CAWSTON PARISH COUNCIL Norfolk Boreas Offshore Windfarm Inquiry Deadline 14 Submission

Comments on Deadline 13 documents

13 APPENDIX 6 SCHEME OF HIGHWAY MITIGATION (B1145, CAWSTON)

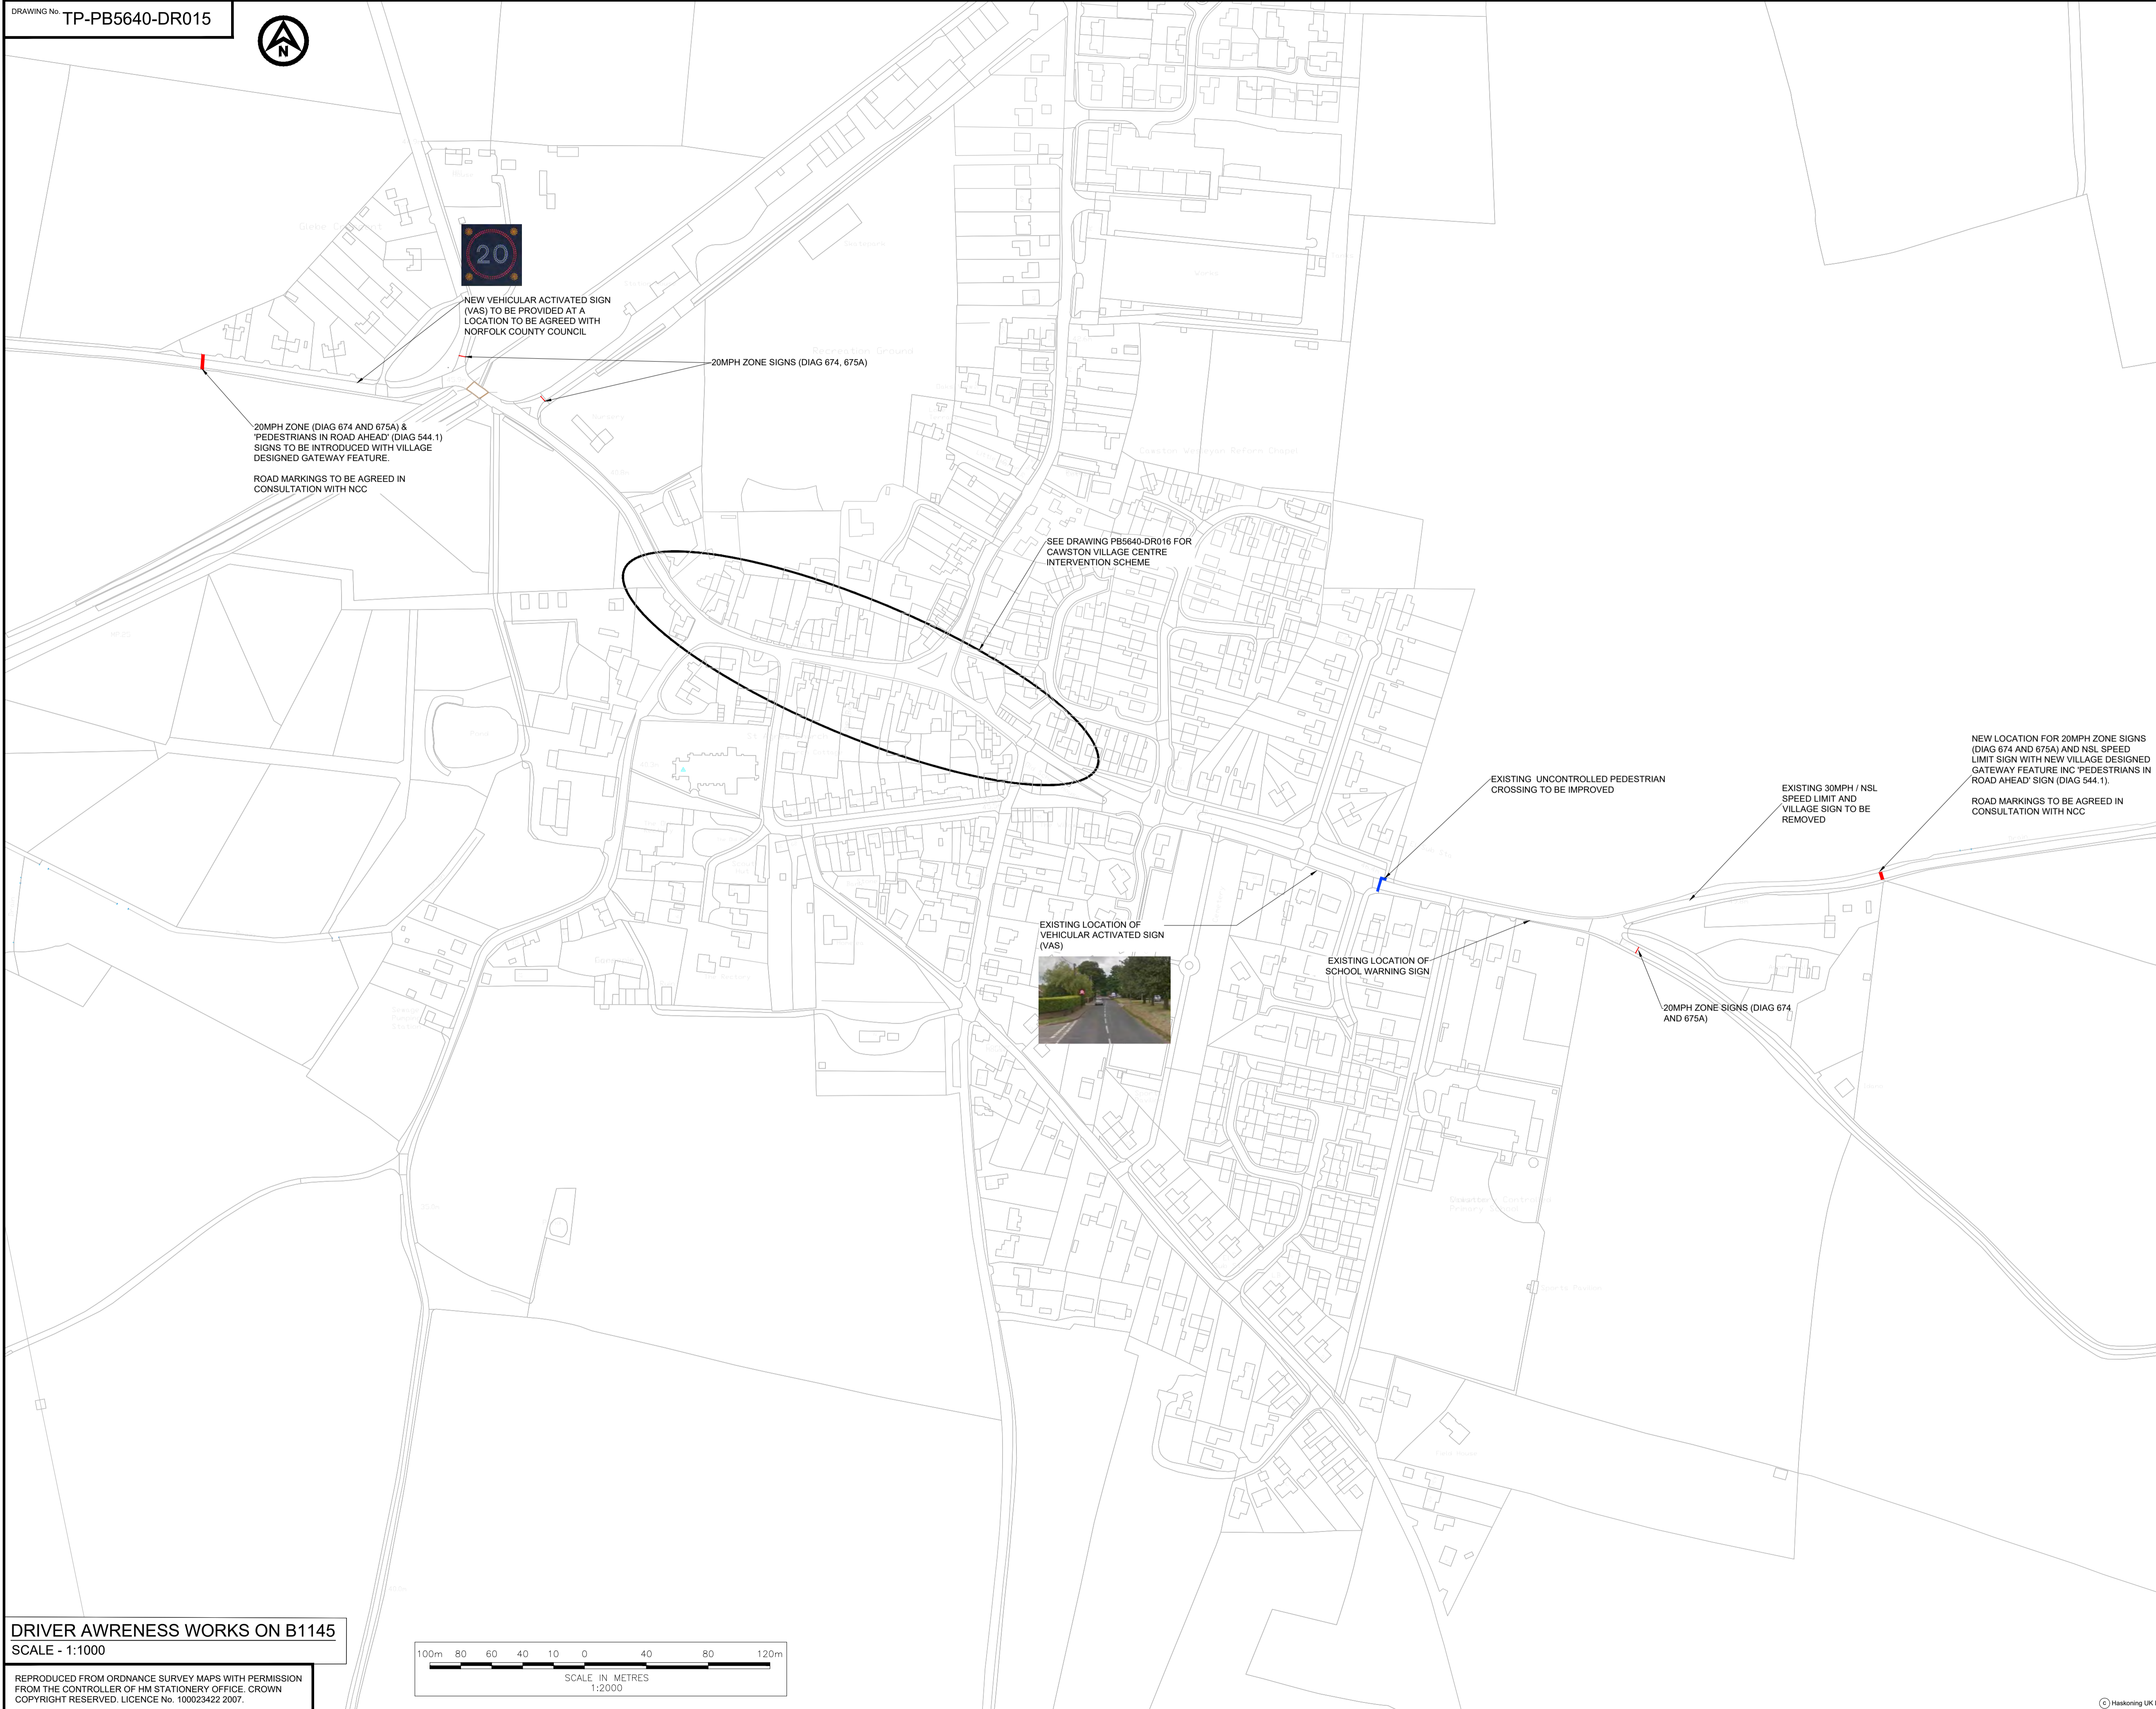
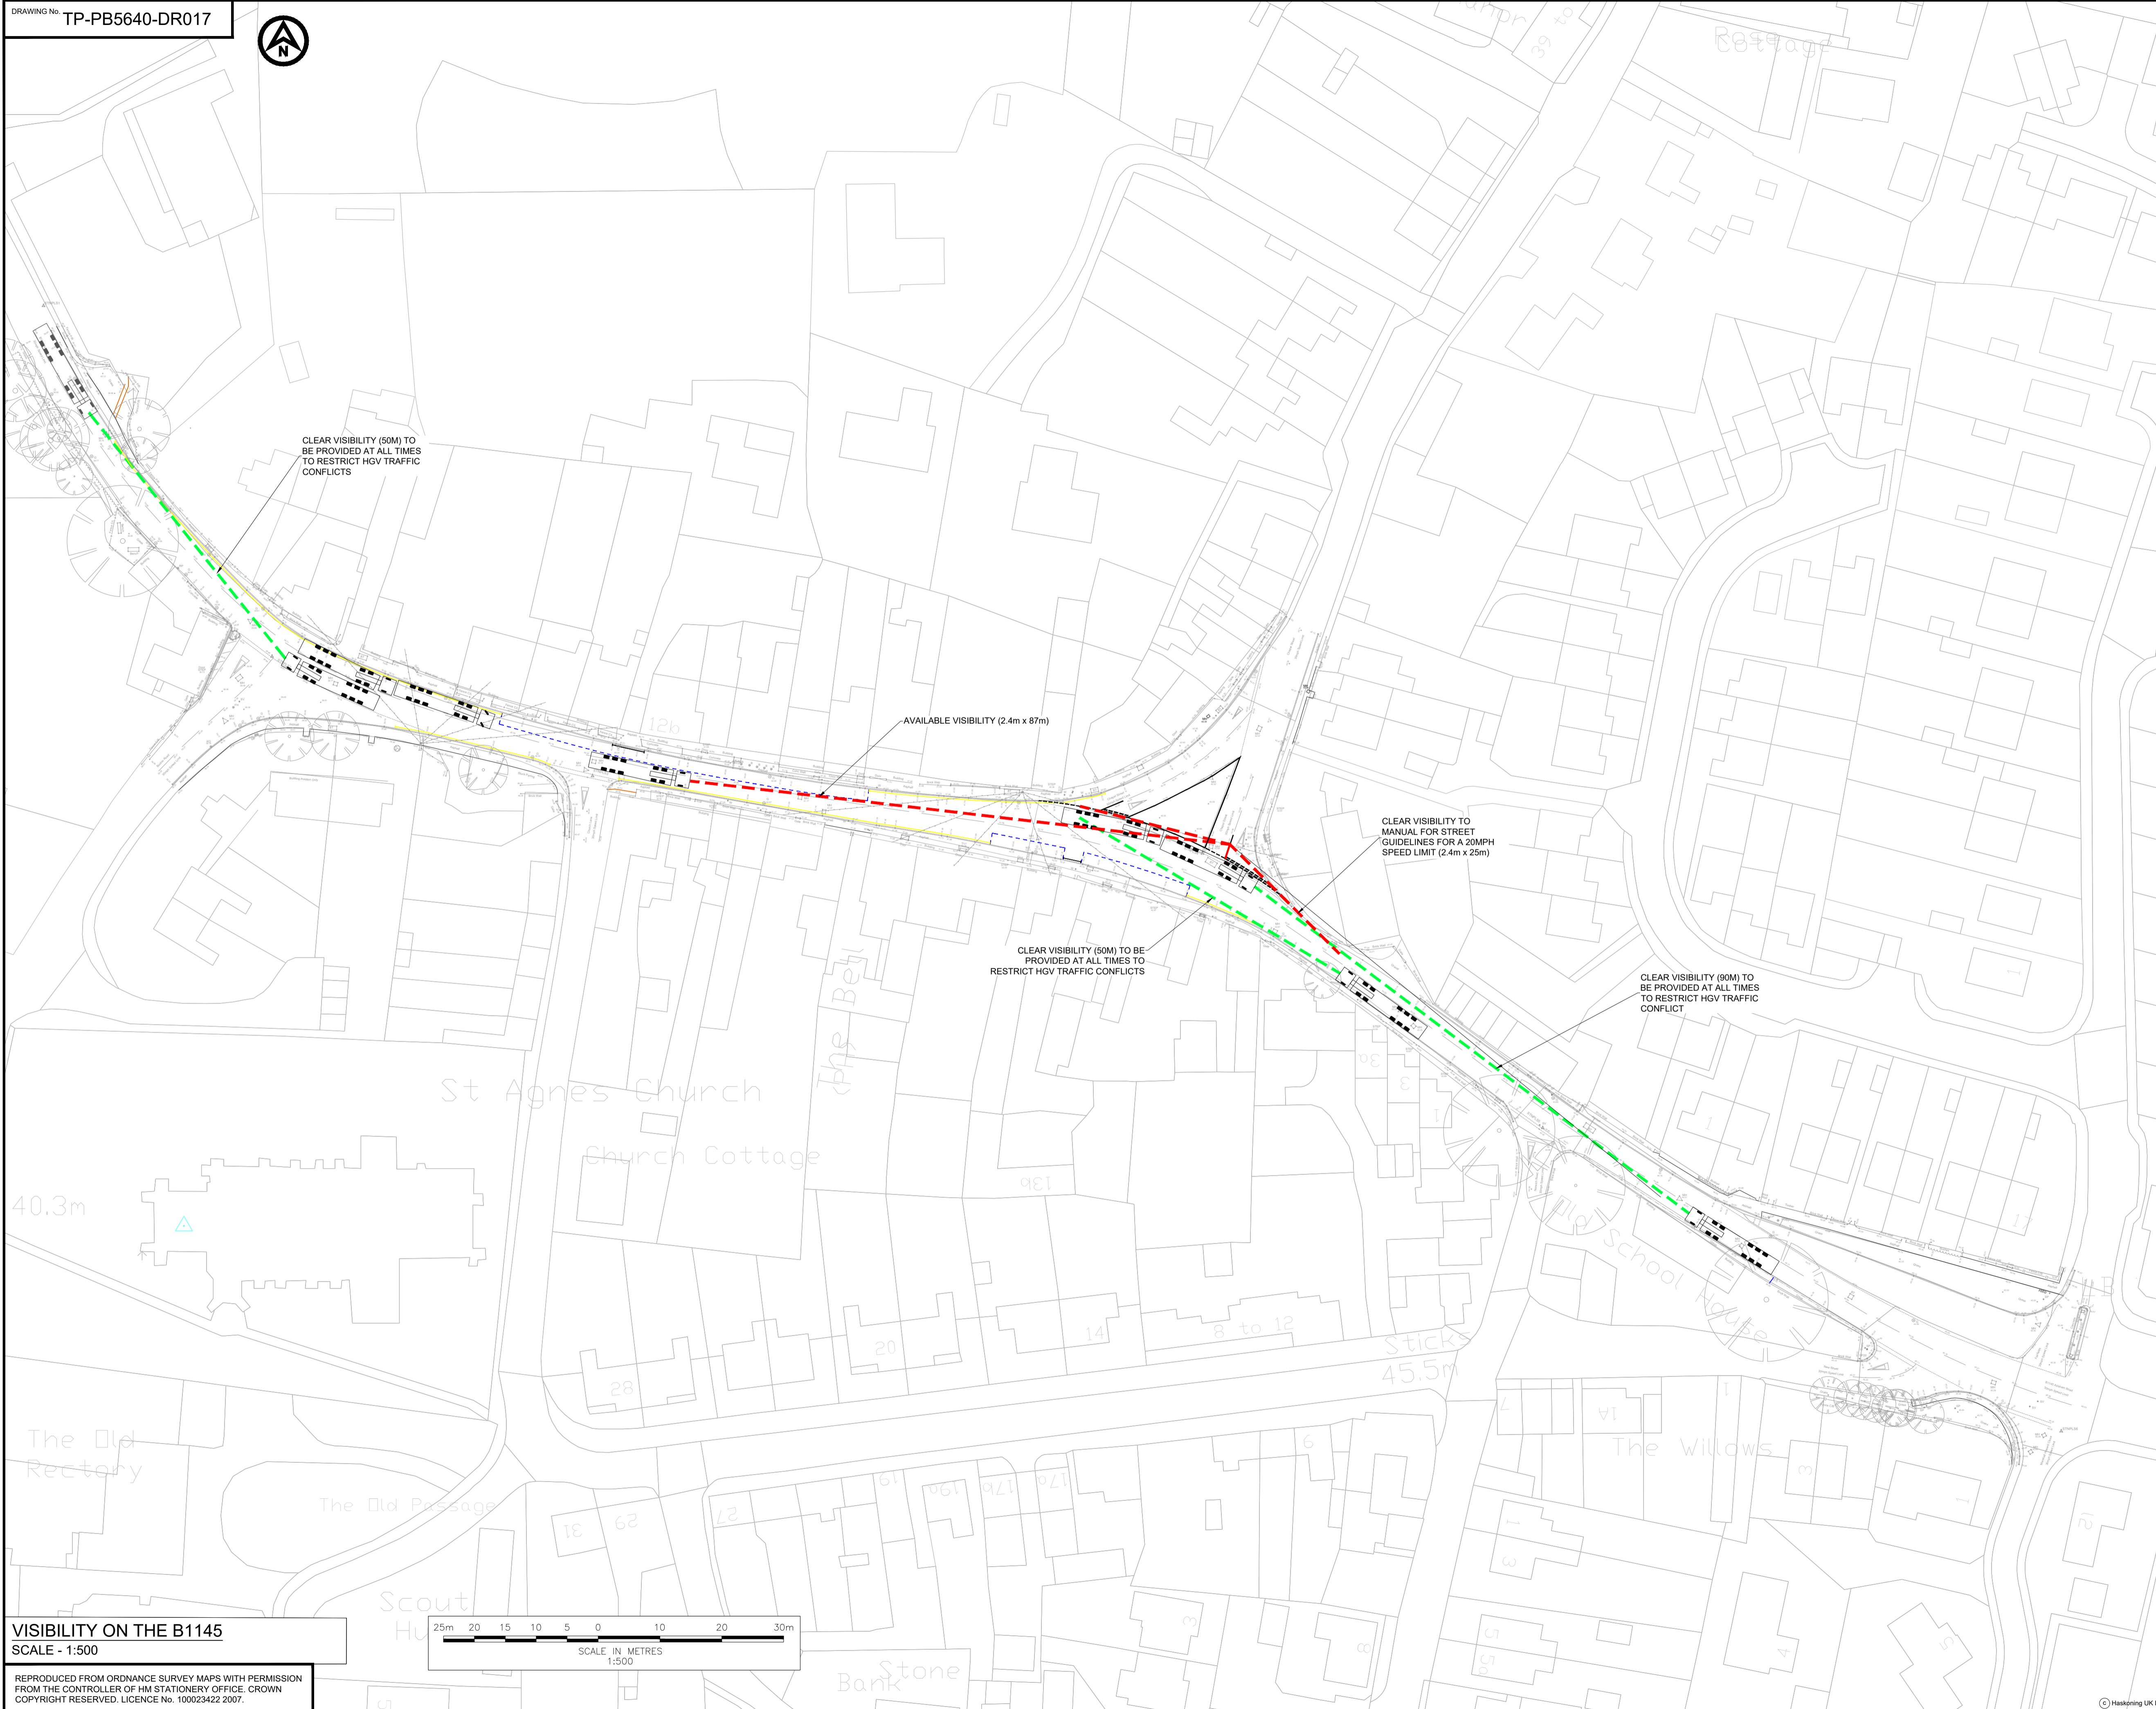
Cawston Parish Council's view remains that the proposed Cawston Highway Intervention Scheme is inadequate to mitigate the impact of the applicant's construction traffic on the village and its residents.

The HIS presented in Boreas is not identical to Vanguard; it is a whole new scheme and is being examined here for the first time. Although the Applicant claims it has “evolved” from the previous scheme we would argue that it is a completely different scheme and should be considered as such.

We suggest that this HIS is not “developed” from NV – it essentially starts again from the status quo plus a few signs and changes to road layout, which are then claimed to create a 20mph zone, with no improvements to pedestrian amenity.
